CITY OF ALBUQUERQUE

June 9, 2017

Re: The 24's @ Uptown
2424 Louisiana Blvd NE
Traffic Circulation Layout
Architect's Stamp 05-23-17 (H19D001)

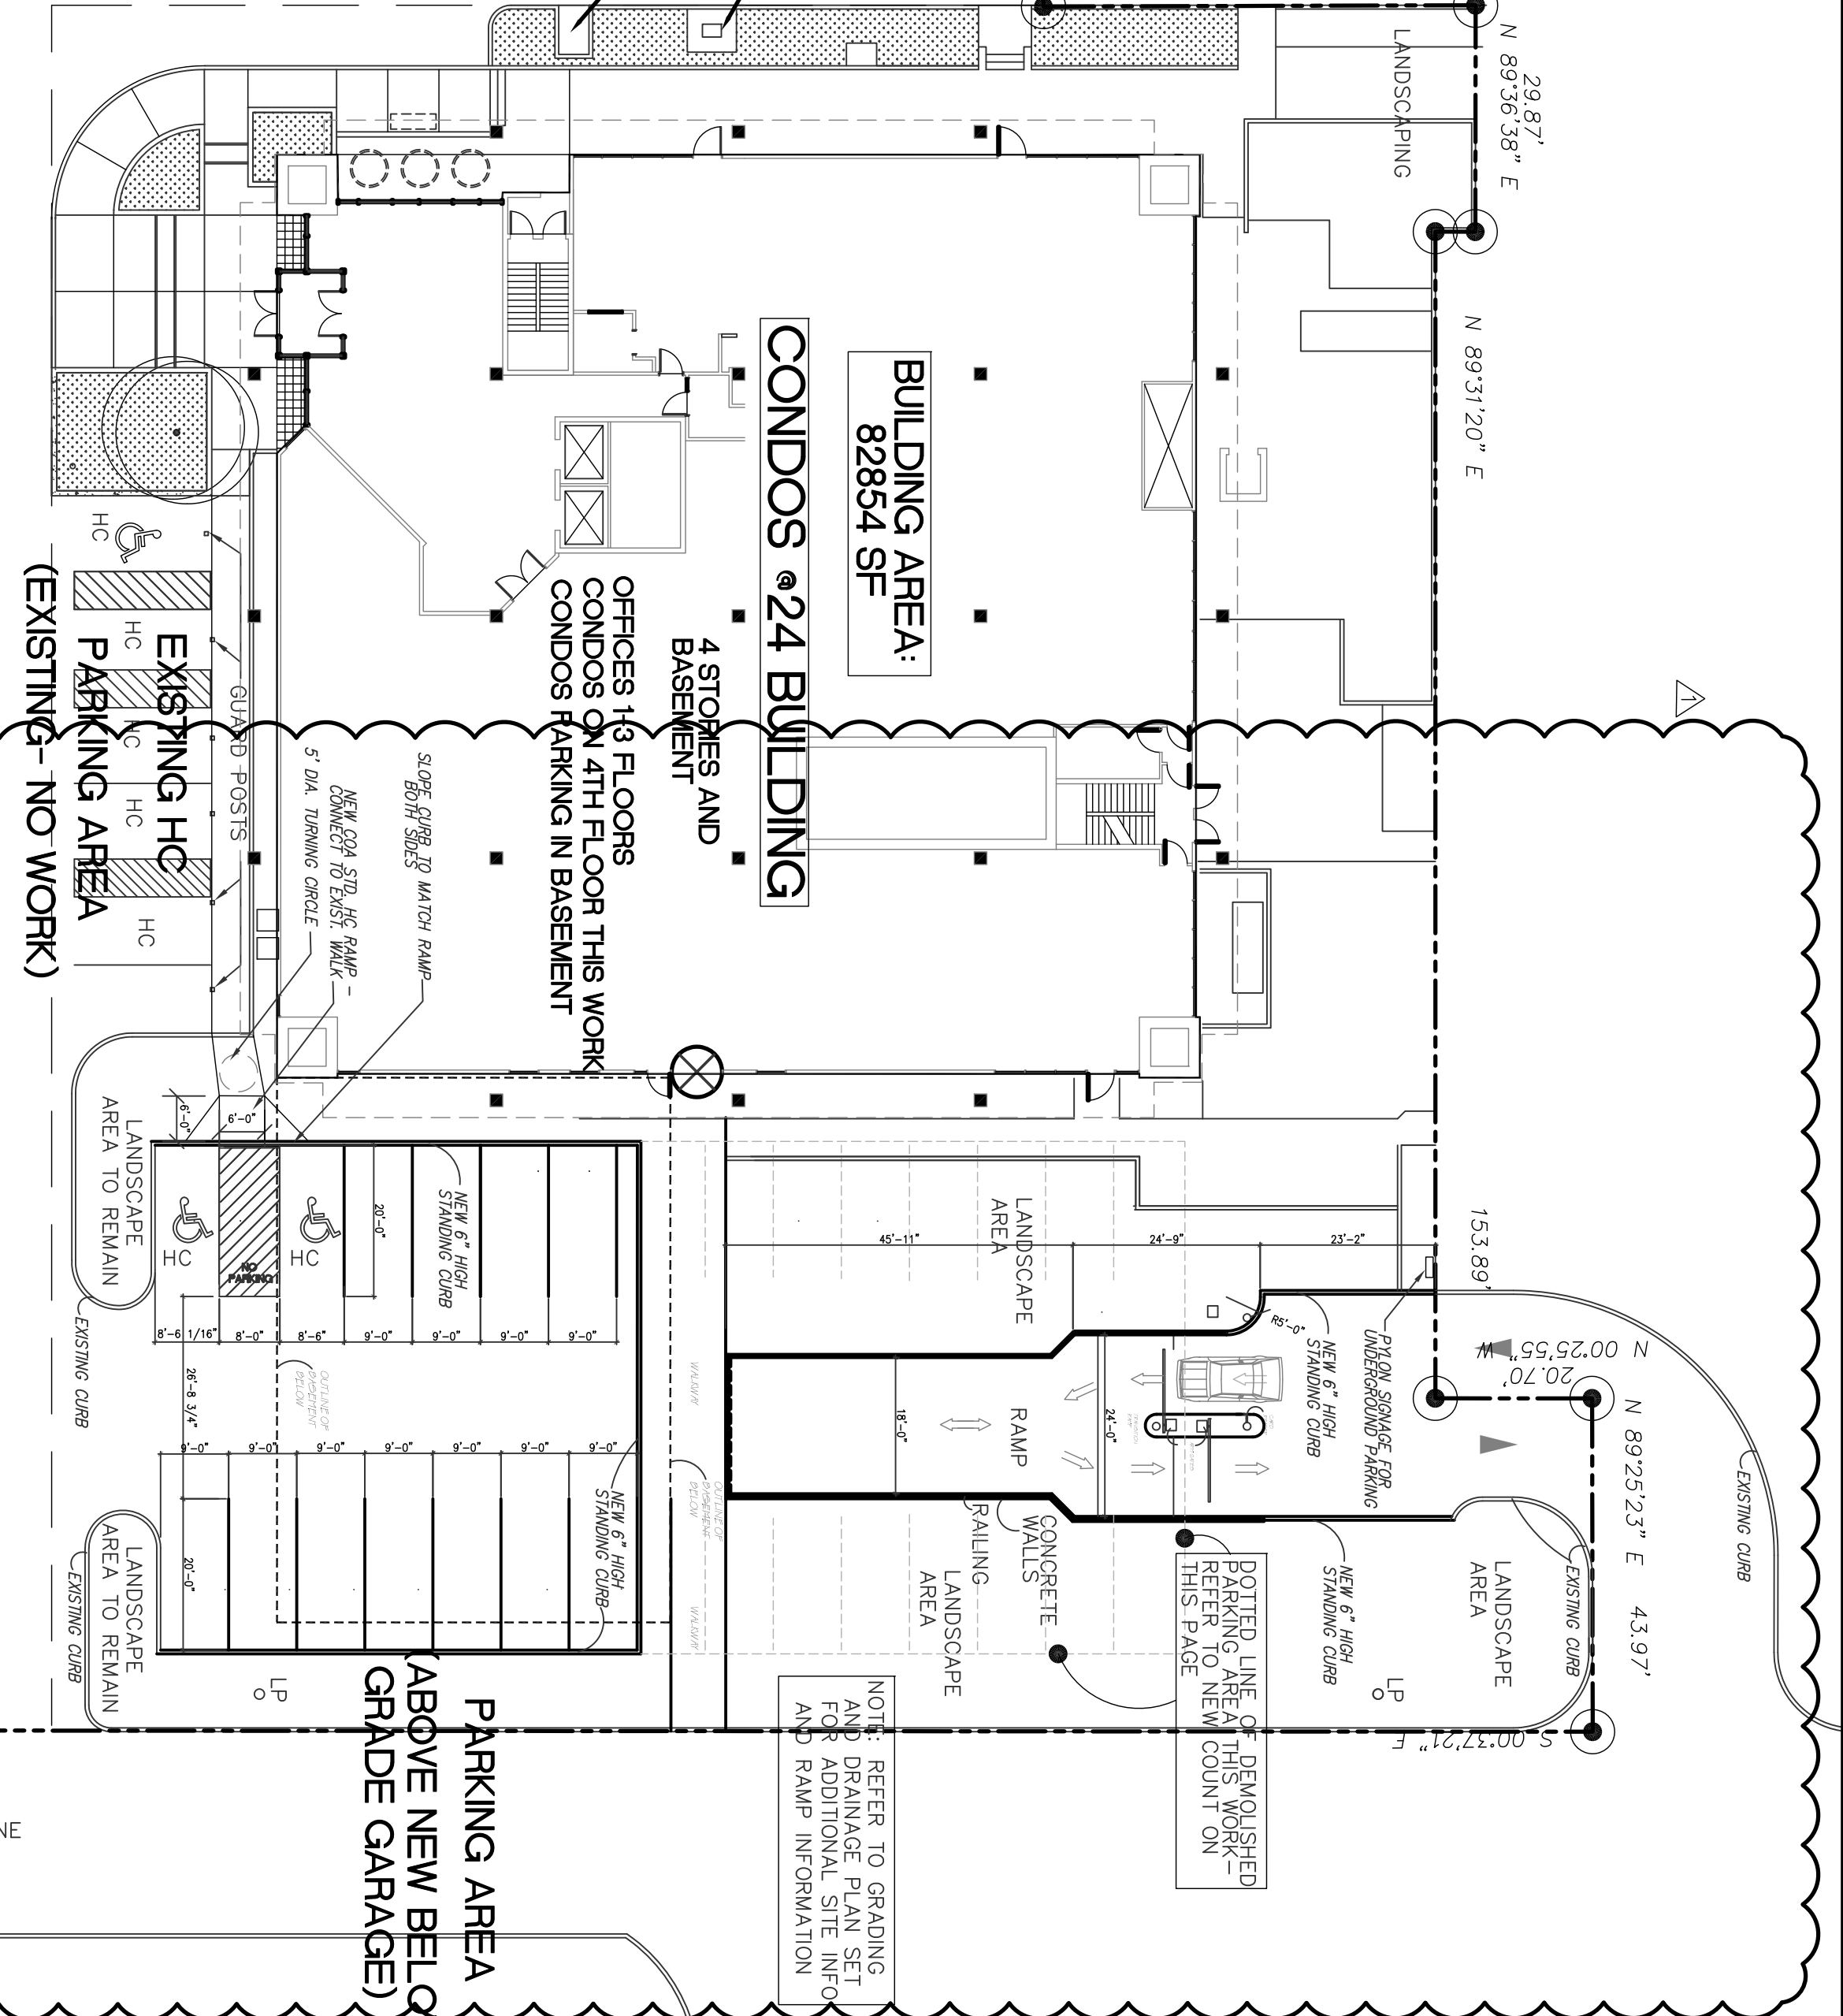
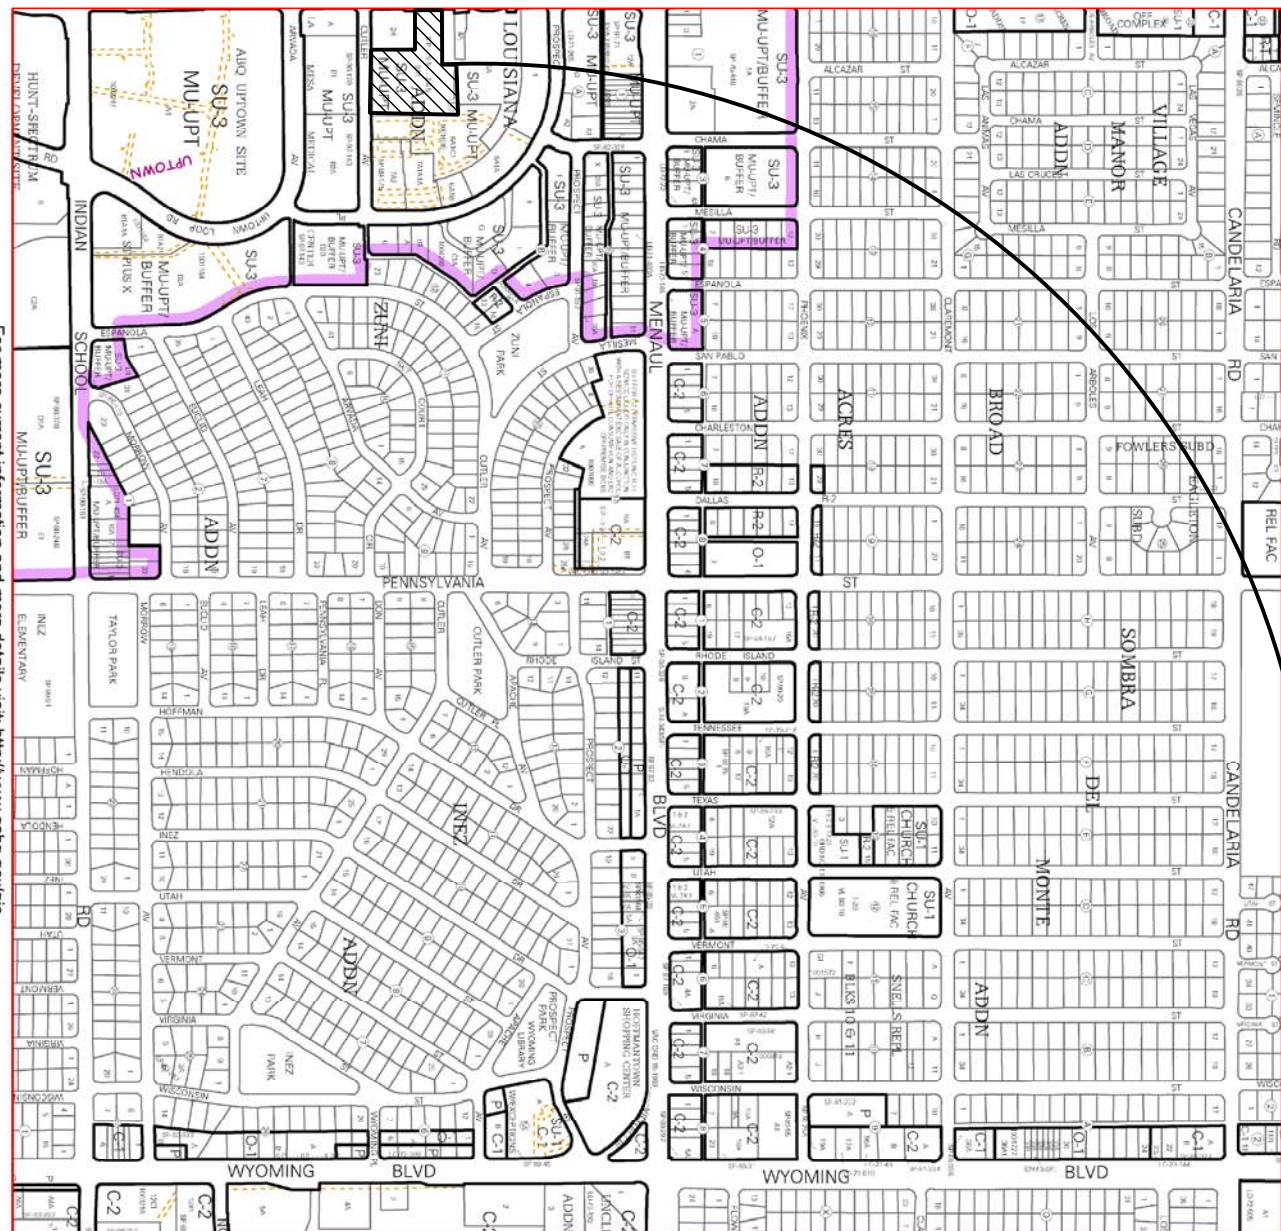
1. The proposed parking spaces located at the east entrance of the parking garage must be removed.
2. The handicap accessible spaces must be a minimum of 8.5 ft. in width.

3. The handicap accessible spaces must include an access aisle. Van accessible aisles should be 8ft wide; all others should be 5ft wide.
4. The ADA accessible parking sign must have the required language per 66-7-352.4C NMSA 1978 **"Violators Are Subject to a Fine and/or Towing."** Please call out detail and location of HC signs.

5. The ADA access aisles shall have the words **"NO PARKING"** in capital letters, each of which shall be at least one foot high and at least two inches wide, placed at the rear of the parking space so as to be close to where an adjacent vehicle's rear tire would be placed. (66-1-4.1.B NMSA 1978)

6. Per DPM, a 6 ft. wide ADA accessible pedestrian pathway is required from the HC parking stall access aisles to the building entrances. Please dimension all ADA access aisles.

7. A ramp with a 5' radius located behind the ramp must be provided at the above ground ADA access aisle.
8. One-way vehicular paths require pavement directional signage and a posted **"Do Not Enter"** sign at the point of egress. Please show detail and location of posted signs for all one way paths.

9. Provide dimensions and radii for the one way entrance to the new above ground parking area.
10. Signage for above and underground parking must be provided.

11. Please provide a note and details regarding the access control to the underground parking.
